# Response to Submissions

100 Bennelong Parkway, Sydney Olympic Park  
SSD 6246

19 November 2014

Drawing Title
Shadow Studies
Shadow Studies - Dec 21 Sheet 2

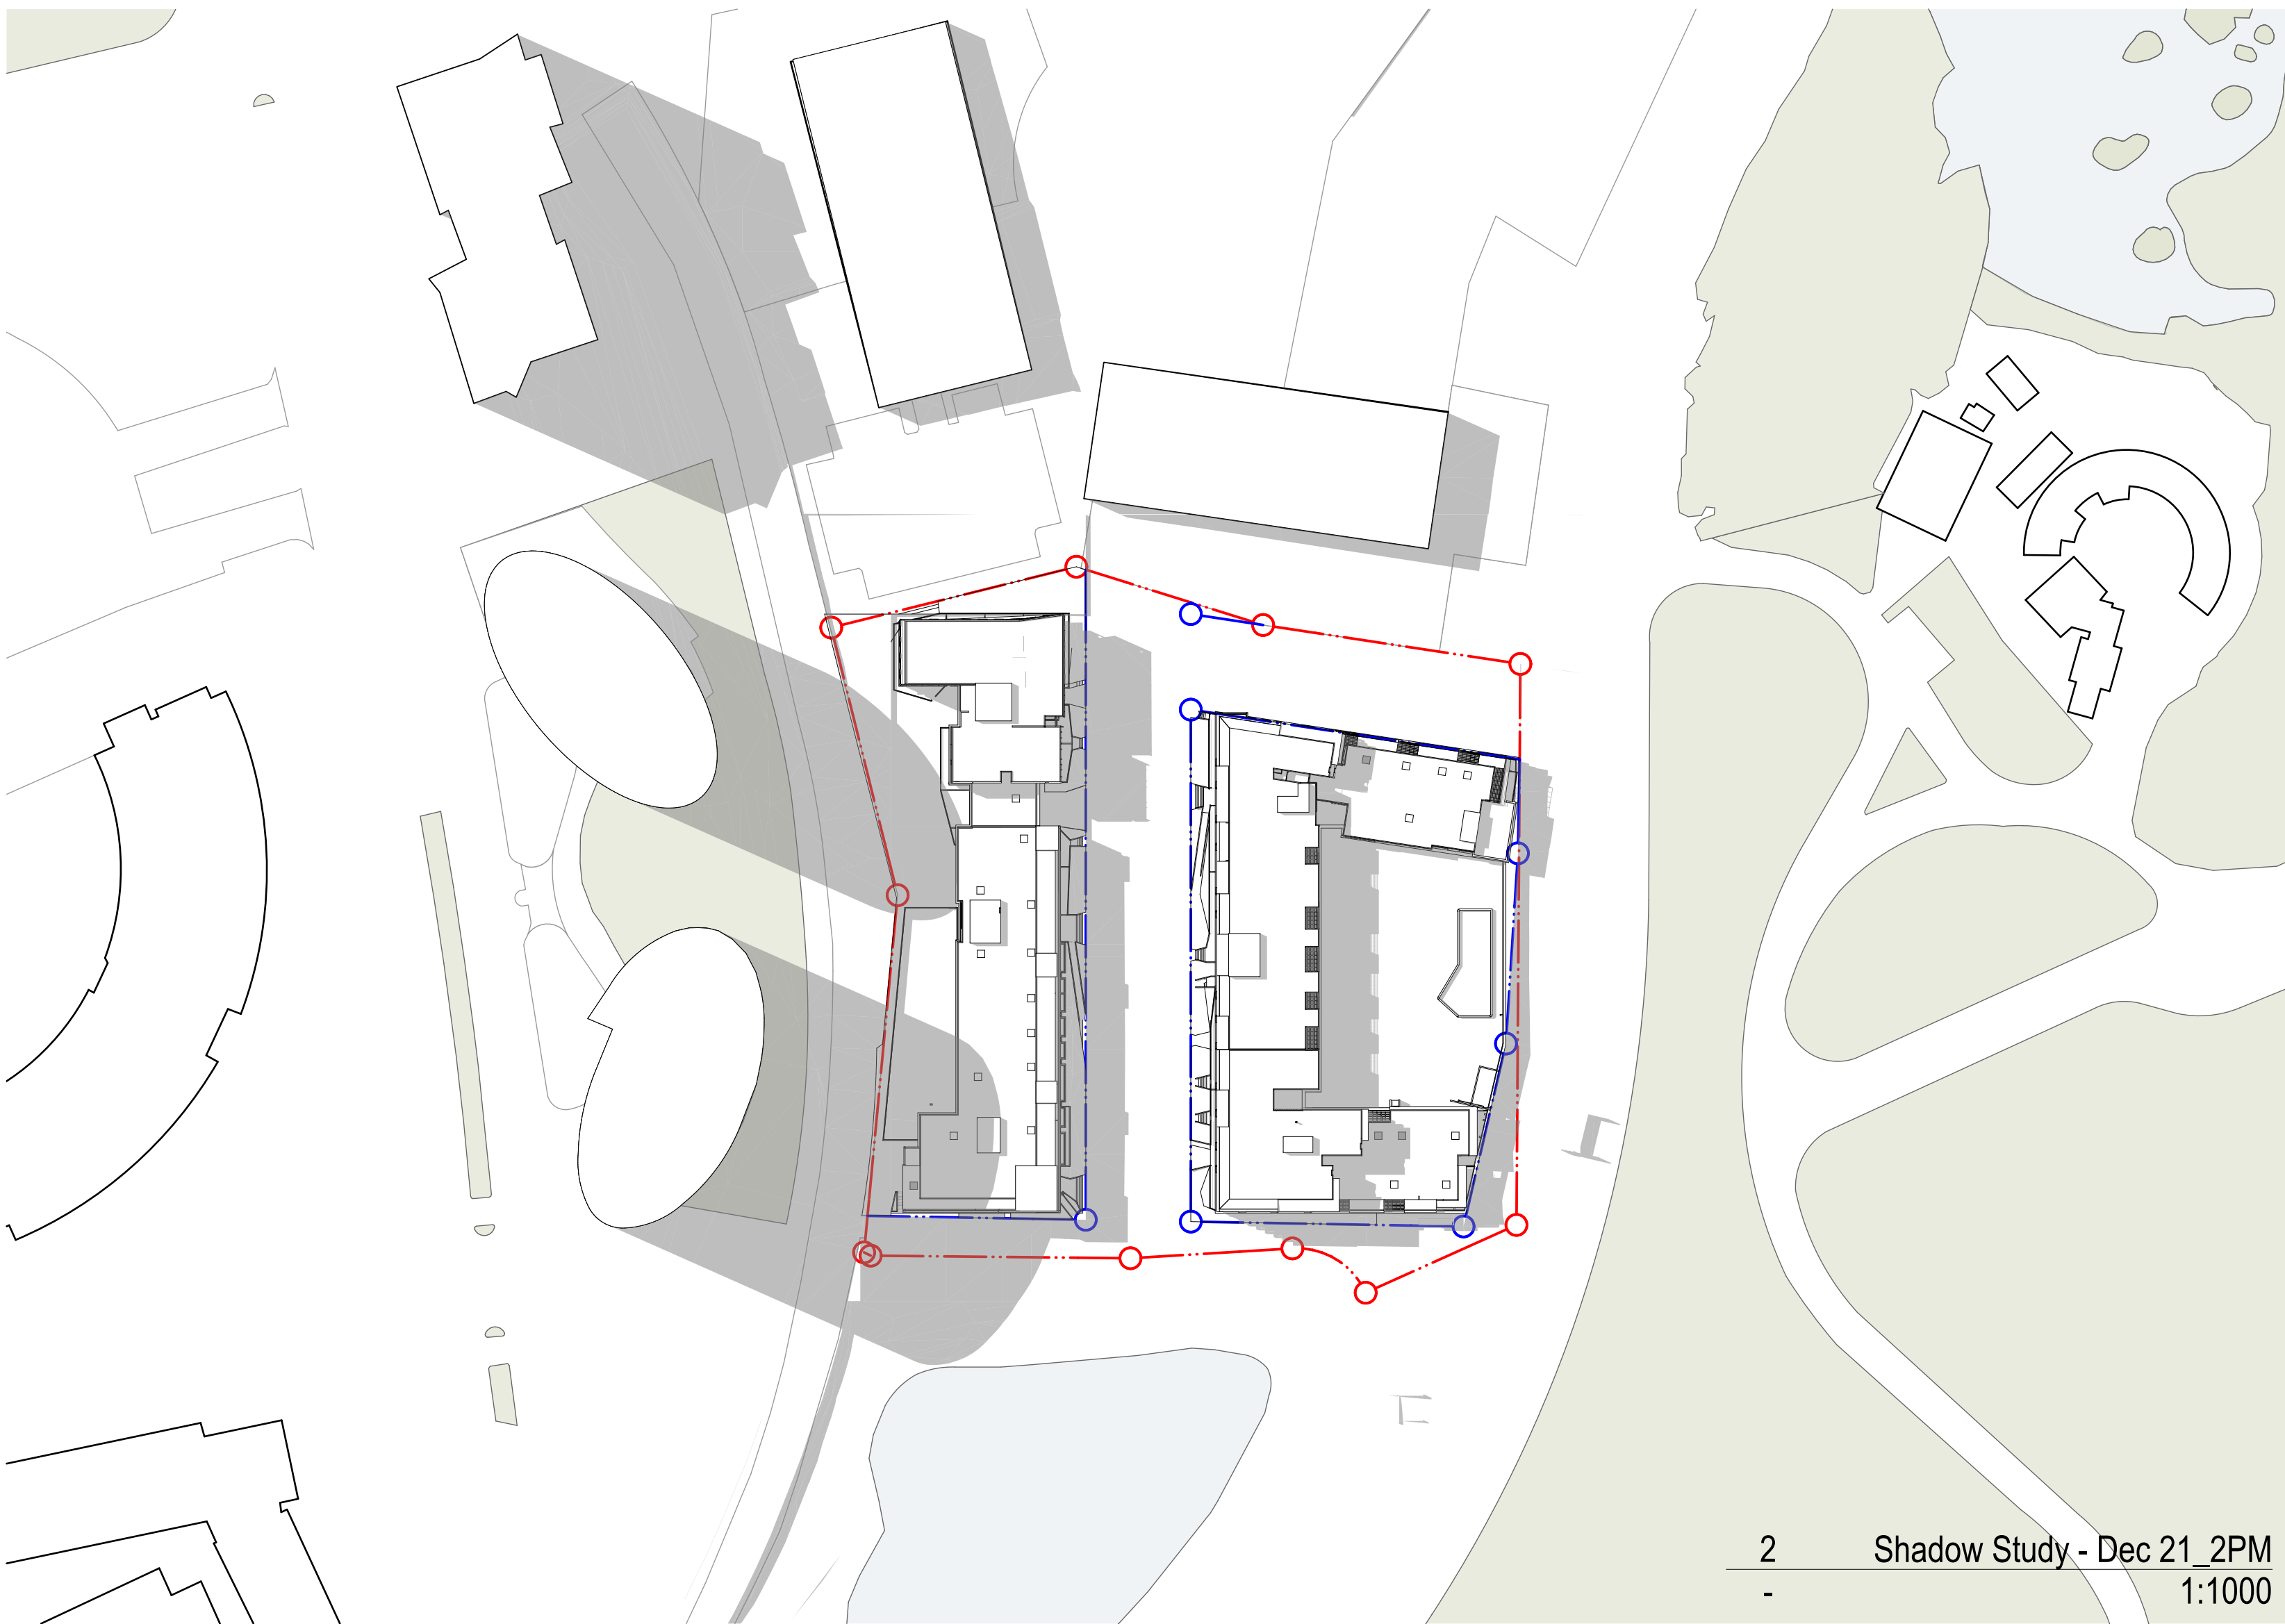
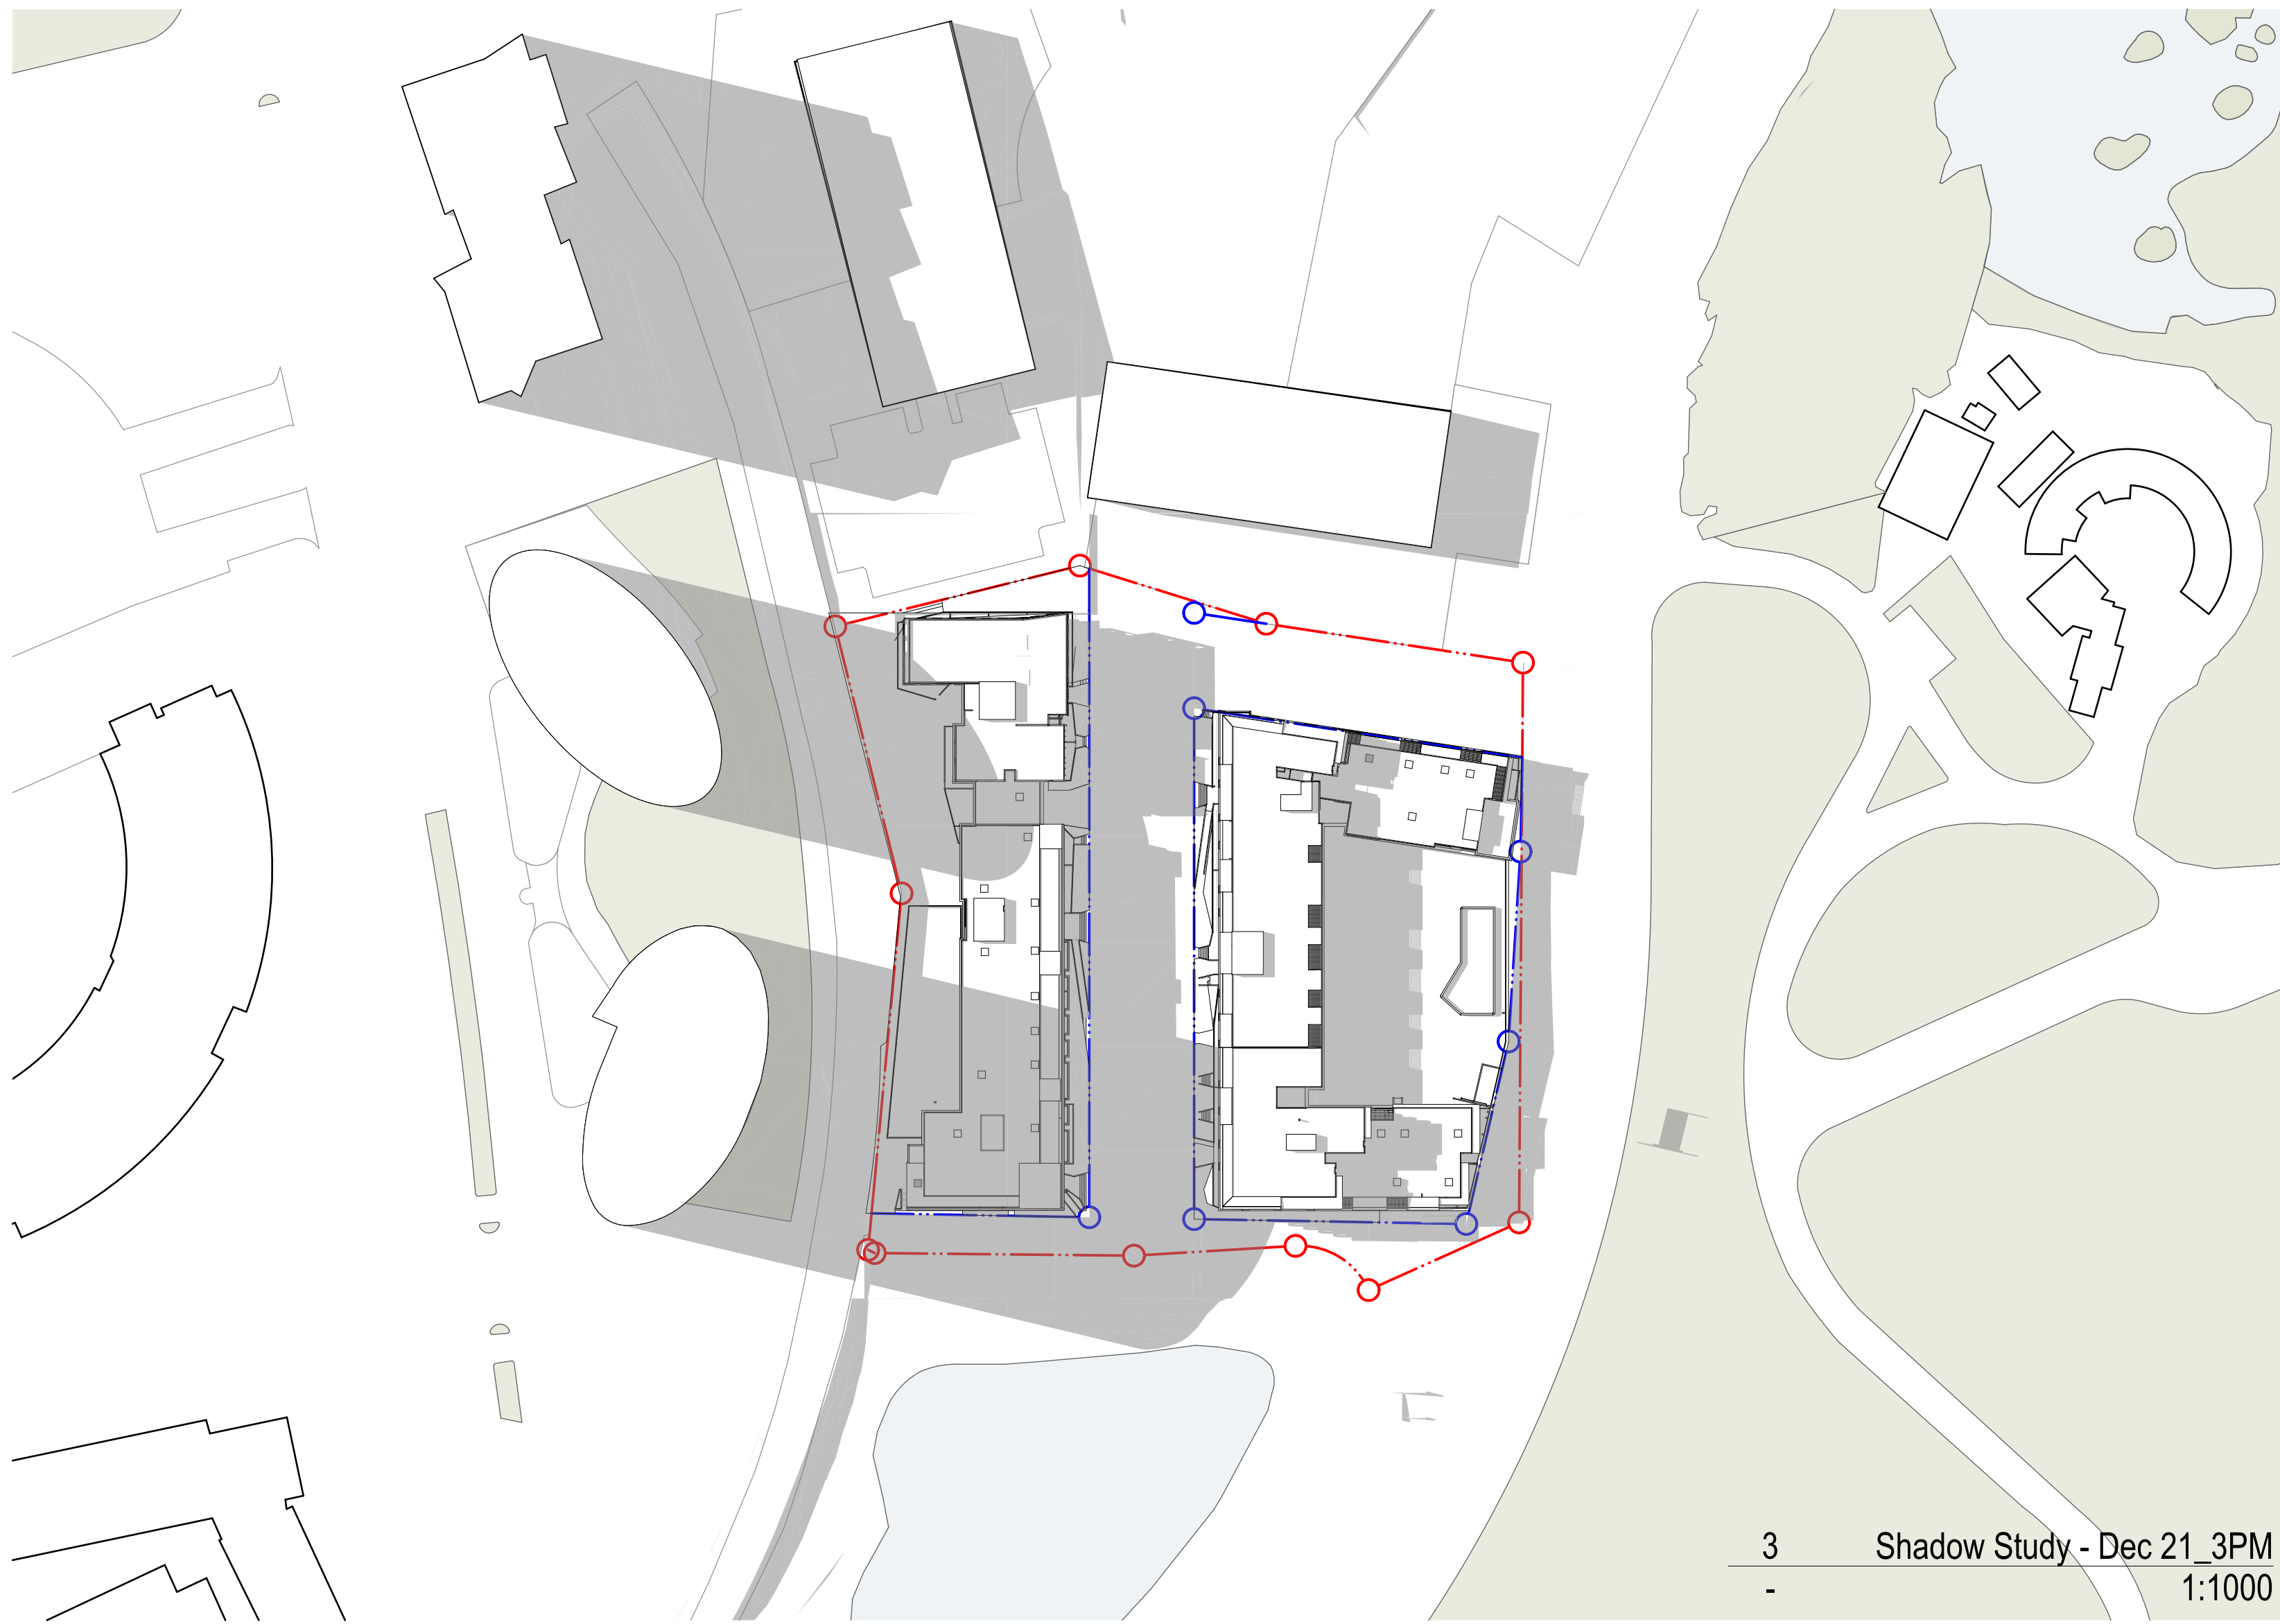
SOPA seeks compliance with the solar access requirements of both the SOPA Masterplan and the 3-hour category of the Residential Flat Design Code.

The proposal has been designed with the footprints of the buildings to accord with the SOPA Masterplan. Further, solar access to the site is adversely affected from 2.30pm onwards by the existing towers to the west of the site. **Figure 1** below contains an extract from the solar access report. It shows that from 2.30pm onwards, the subject site is affected by the buildings to the west in terms of solar access. The extent of this impact is great enough to prevent full 3-hour compliance, as units on the western side of the development will begin to lose sun from this time of the day onwards.

Substantial work has been done on the amended proposed plans (refer **Annexure 3**) to improve solar access to the proposed units. **Annexure 4** contains a solar access report prepared by SLR Consulting assessing the amended development. The following table presents an overview of the SOPA and RFDC requirements and solar access results of the amended proposal.

In order to fully comply with the solar access requirements of the above, the proposal would need 10 more units with 3 hours solar access to comply with the SOPA MP; and 5 more units with 3 hours solar access to comply with SEPP 65/RFDC. However, there are significant factors influencing the ability of the development to fully comply with the solar access requirements of both controls.
